**Re: Nepean Hospital Redevelopment Stage 1 – Modification Request (SSD 8766 MOD 2)**

This letter has been prepared in response to comments to the landscape architectural drawing set in relation to the Nepean Hospital Redevelopment SSDA Section 4.55. SSD 8766 MOD 2.

Figure 18 | Proposed landscape area near Somerset Street (Sheet 107) (Source: RtS)

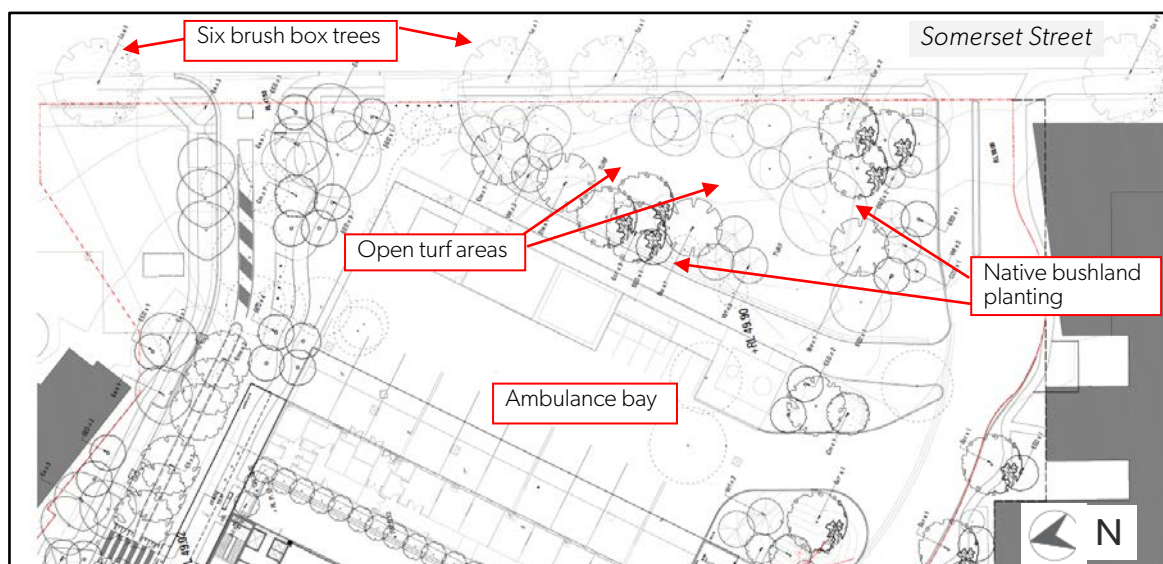
**Council comment 01:** The area to the east of the proposal, between the building and Somerset St has not been documented in detail. Council's Landscape Architect requested the plans from the Department, who confirmed that this area was originally to be retained as existing (a carpark) and this is the reason it has not been documented. More recently it is now to be changed to landscaping and the detailed design is yet to be undertaken. It is therefore requested that detailed documentation be made available to Council to consider the landscape design in this location. Key considerations are the contribution to streetscape, as well as provision of street trees and other verge treatments such as paving and street furniture in accordance with the Kingswood Public Domain Technical Manual ([https://www.penrithcity.nsw.gov.au/images/documents/building-development/planning-zoning/Kingswood\\_Public\\_Domain\\_Manual.pdf](https://www.penrithcity.nsw.gov.au/images/documents/building-development/planning-zoning/Kingswood_Public_Domain_Manual.pdf) - this document is due for review in 2020 and therefore liaison between the applicant's designer and Council would be of benefit to address any more recent issues relating to the Manual)

**Response 01:** The area along Somerset Street was intended not to be a place of gathering/allowing the prospect of loitering near key aspects of the hospital such as the ambulance bay and key service points. On reflection of the Kingswood Public Domain Manual provided by Council the specified street tree for along Somerset Street would be a 400lt Brush Box (*Lophostemon confertus*) which had not been previously documented. This will be included within the scope of the detailed documentation; Refer Sheet 107;
